KITTITAS COUNTY FIRE MARSHAL'S OFFICE

September 25, 2014

Re: Sullivan (SP-14-00003)

After conducting a review of the above named project, I have the following comments:

**SULLIVAN SHORT PLAT**

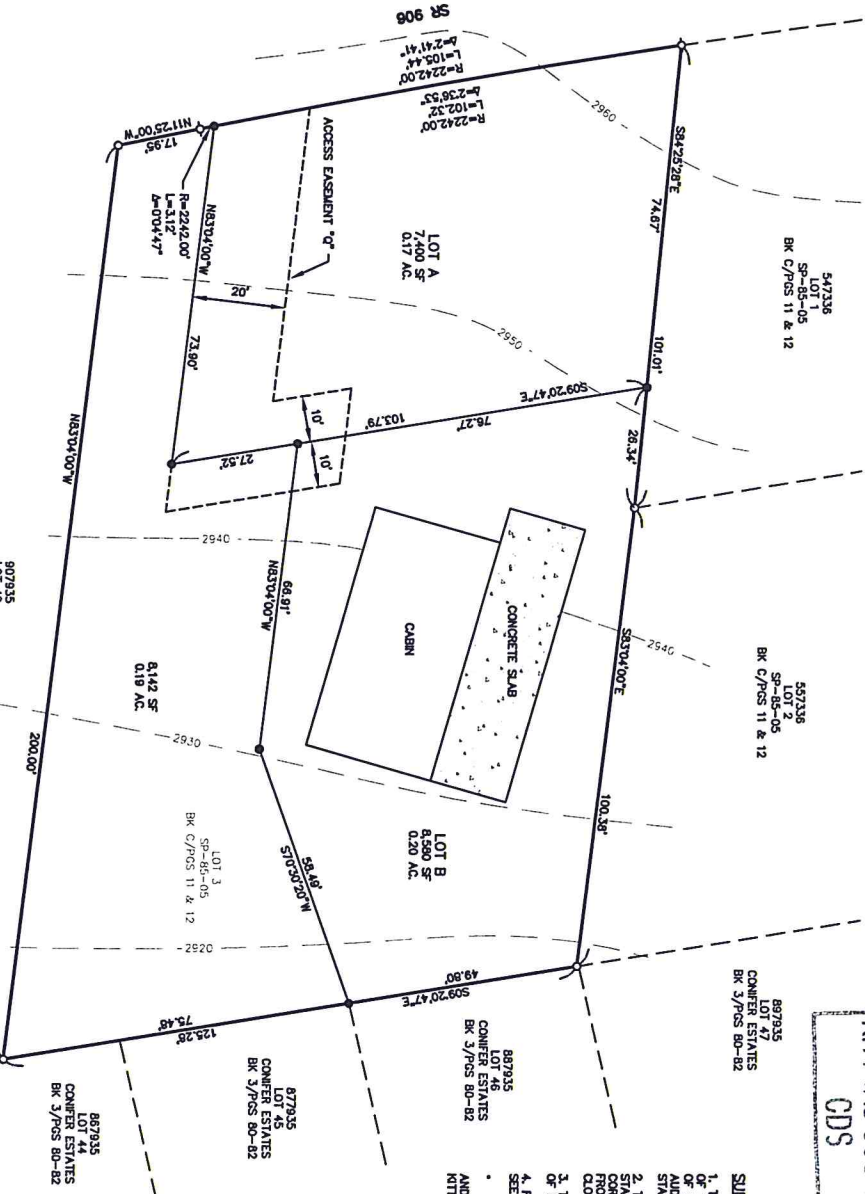
- The access/driveways for the properties to be created were not noted on the plans submitted. Any driveway greater than 150' in length shall be 16' in width. Driveways less than 150' shall be no less than 12' in width.
- The addresses shall be posted at the front of the property and easily visible from the road to emergency responders.
- Due to the small nature of these lots, LP-Gas propane tanks will not be allowed for these lots.
- Any new structures or substantial development to existing structures will require a WUI permit.
- All future development must comply with the International Fire Code.
